Our ref:DOC20/130319

Your ref: SSD 9667

Subject: EES comments on Response to Submissions and Preferred Project Report for Light Horse Interchange Business Hub Eastern Creek – SSD-9667 – 165 Wallgrove Road and 475 Ferrers Road Eastern Creek

Subject: EES comments on Response to Submissions and Preferred Project Report - Light Horse Interchange Business Hub Eastern Creek – SSD-9667 – 165 Wallgrove Road and 475 Ferrers Road Eastern Creek

Drawing Name:
Landscape Master Plan

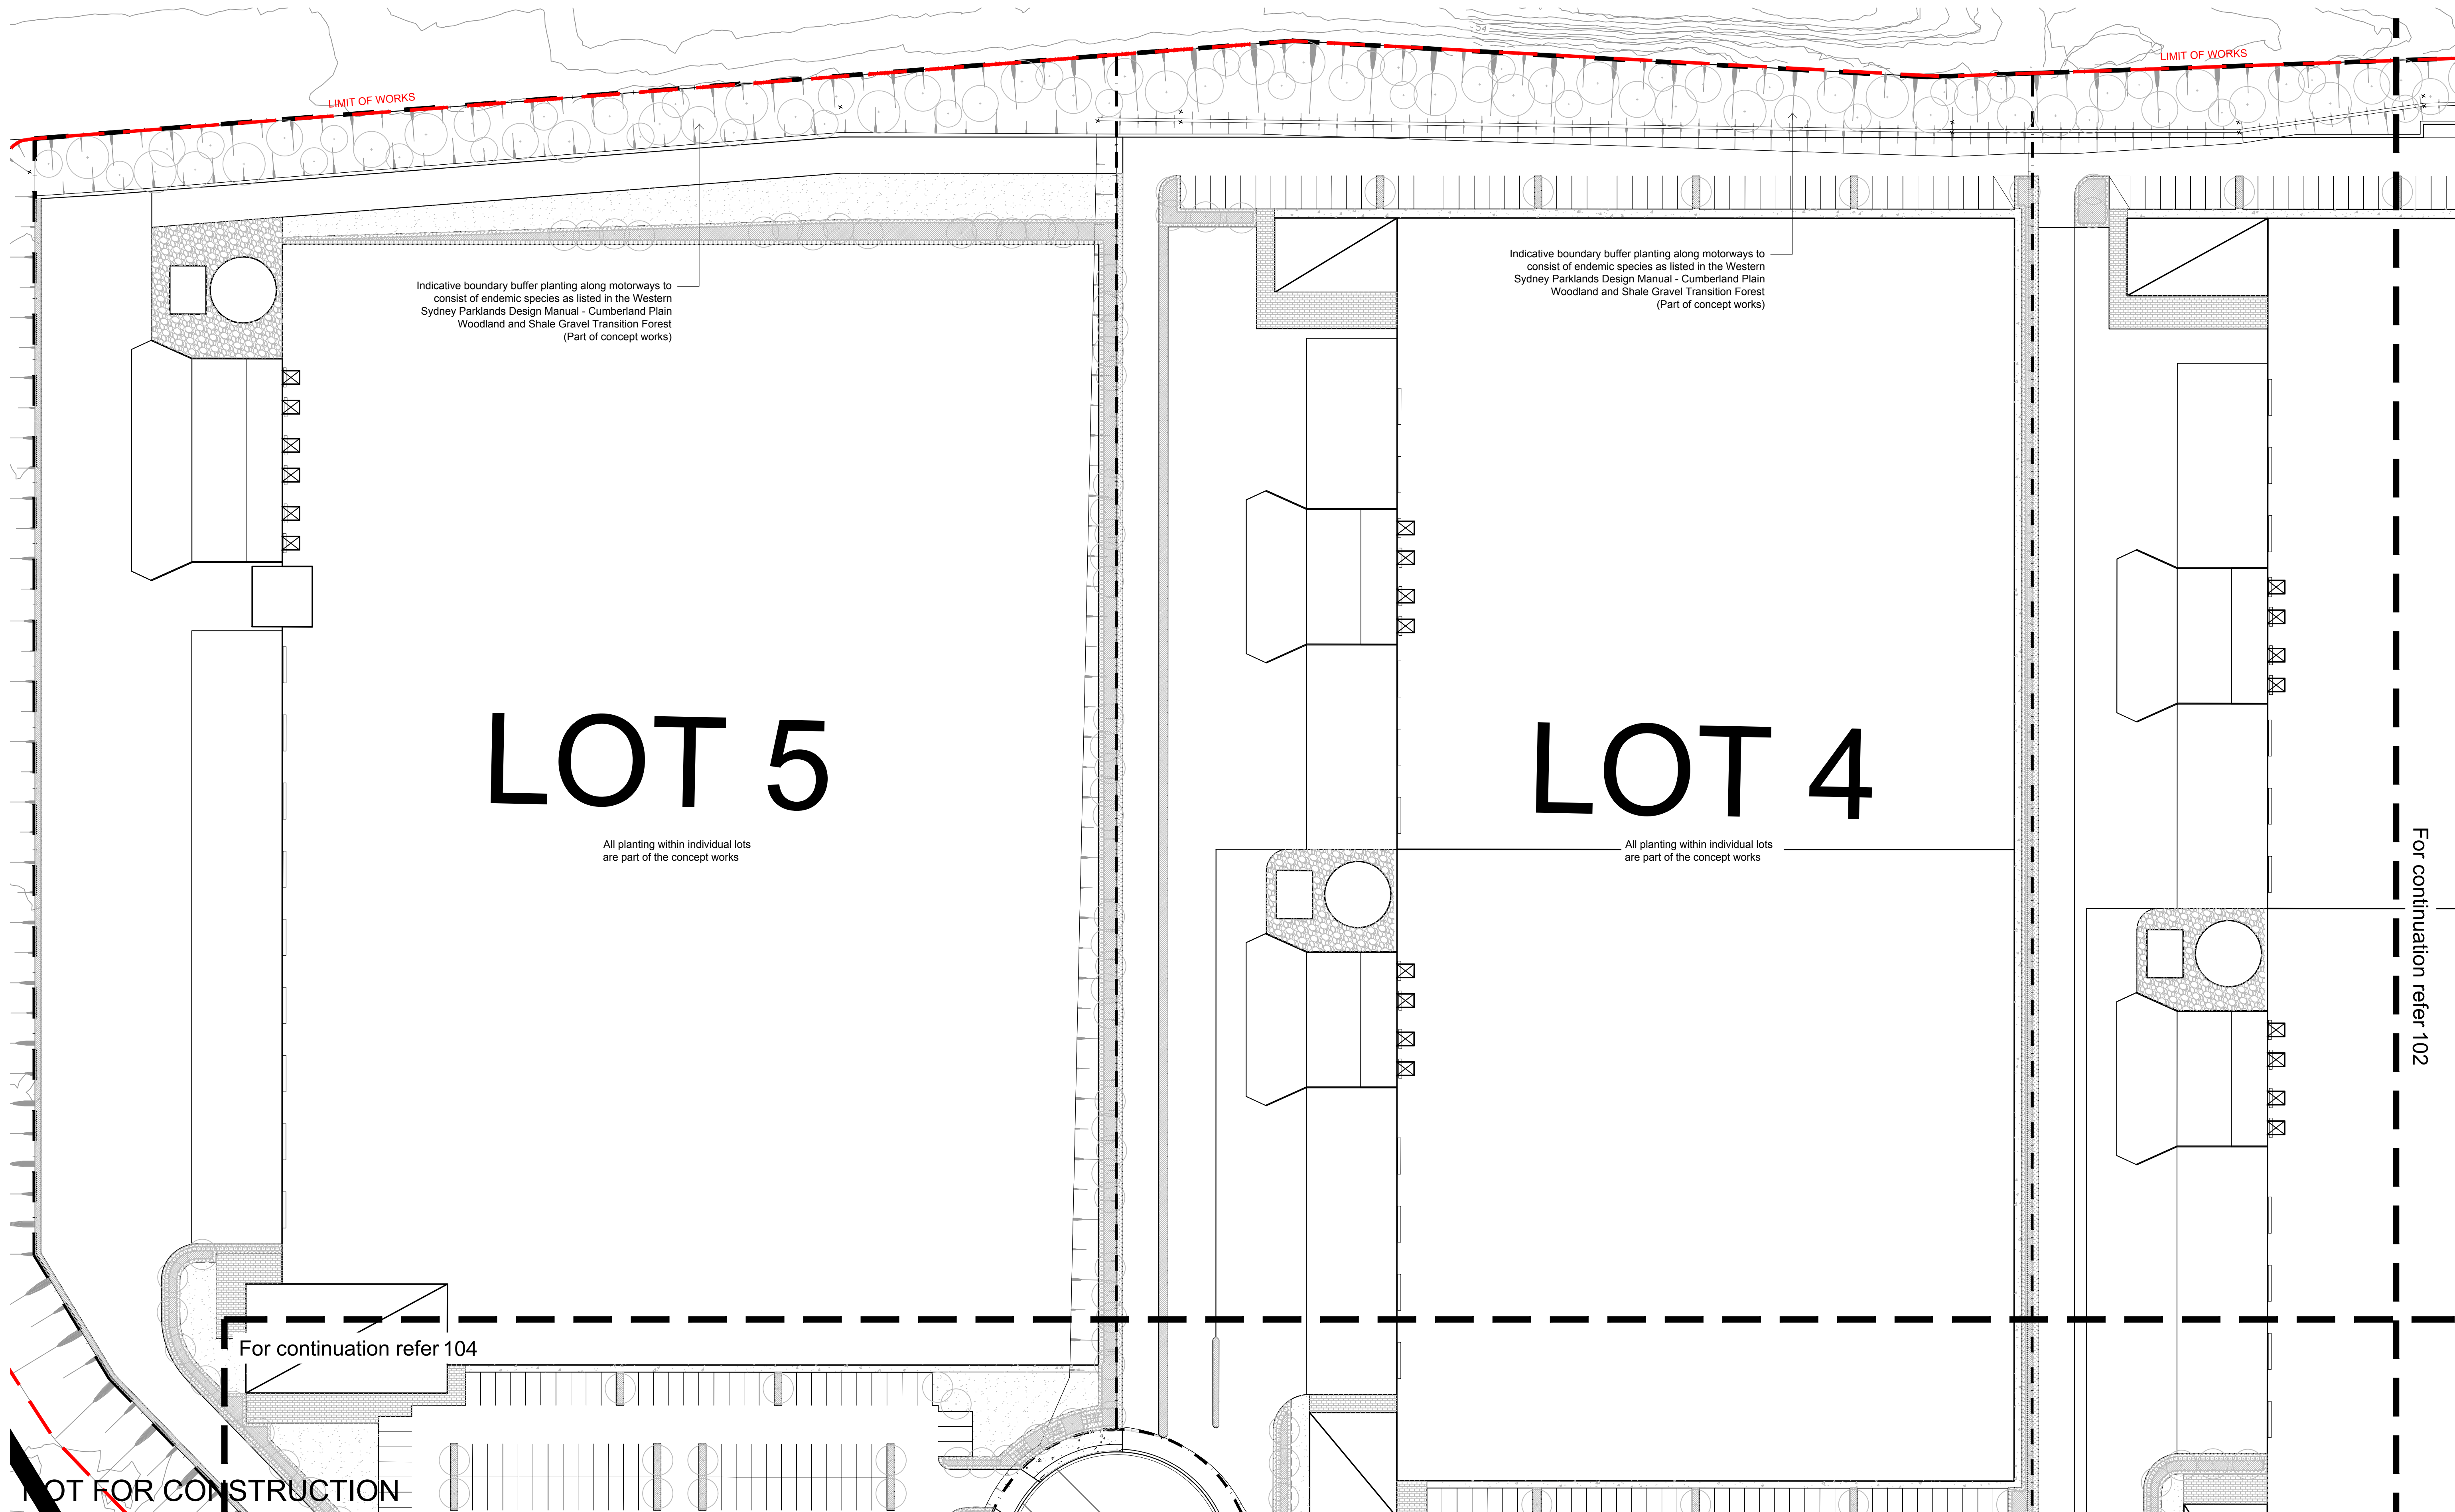
EES previously recommended the Plant Schedule list is amended and a diversity of local native provenance species are planted in the street planting and development lots (rather than plant exotic or non-local natives). The RTS notes the Plant Schedule has been amended to include a diversity of local native species (page 27). The amended Plant Schedule (Appendix C) has removed the exotic London Plane Tree as a street tree and replaced it by Grey Box (*Eucalyptus moluccana*). EES supports the use of Grey Box as a street tree, as it is a local native species of the Cumberland Plain Woodland (CPW). As Forest Red Gum (*Eucalyptus tereticornis*) also occurs in the CPW on site (page 27 of BDAR), EES recommends it is also added to the street tree plant list.

EES repeats that a diversity of local native provenance species should also be used in any landscaping of the development lots.

The RTS does not provide details on the total number of trees that are to be removed from the site and hence the number of replacement trees required if a tree replacement ratio of greater than 1:1 were applied. In terms of replacement trees, the Landscape Plan indicates 239 trees are to be planted on site (comprising 130 street trees and 109 trees in the landscaped buffer zone). It is unclear how many trees are proposed to be removed from along Eastern Creek (if the bridge crossing option is approved), or from along Eskdale Creek or how many replacement trees are to be planted along the creeks.

EES suggested advanced and established local native trees are used preferably with a plant container pot size of 100 litres or greater. The updated Landscape Plan proposes to use a pot size of 100L for the street tree planting and the Buffer Zone planting. The RTS notes pot sizes will be selected based on the conditions for establishment (page 27).

EES advised that sufficient area/space needs to be provided to allow the trees to grow to maturity. In response the RTS notes areas of the subject land are to be managed in accordance with the VMP (page 27). It is unclear if the VMP applies to the whole site (such as street planting, landscaped buffer areas) or only to the riparian corridors. The CRDR indicates the VMP applies only to certain riparian areas along the creeks and not the whole site (Figure 4, page 8).

The proponent needs to ensure that any tree planting across the site allows sufficient area/space to allow the trees to grow to maturity. EES previously recommended the Landscape Plan include this detail to demonstrate that this can occur.

- 2) A landscape plan shall be prepared for the landscape buffer areas, street planting and development lots and include details on:
 - the native vegetation community (or communities) that occur or once occurred in the locality
 - a list of local native provenance species to be used in the landscaping from the relevant native vegetation community or communities rather than plant non-local natives or exotic species
 - the quantity and location of plantings
 - the pot size of the local native trees to be planted - advanced and established local native trees preferably with a plant container pot size of 100 litres, or greater for local native tree species which are commercially available. Other local native tree species which are not commercially available may be sourced as juvenile sized trees or pre-grown from provenance seed

- the area/space required to allow the planted trees to grow to maturity
 - plant maintenance regime. The planted vegetation must be regularly maintained and watered for 12 months following planting. Should any plant loss occur during the maintenance period the plants should be replaced by the same plant species.

- 3) Trees removed by the development shall be replaced at a ratio greater than 1:1.
- 4) Native trees removed (including tree hollows and tree trunks greater than approximately 25-30cm in diameter and 3m in length) shall be salvaged and used in the landscaped buffer areas on site; the realigned Erskdale Creek riparian corridor; the Bushland Corridor and the riparian corridors along Eastern Creek and Reedy Creek.
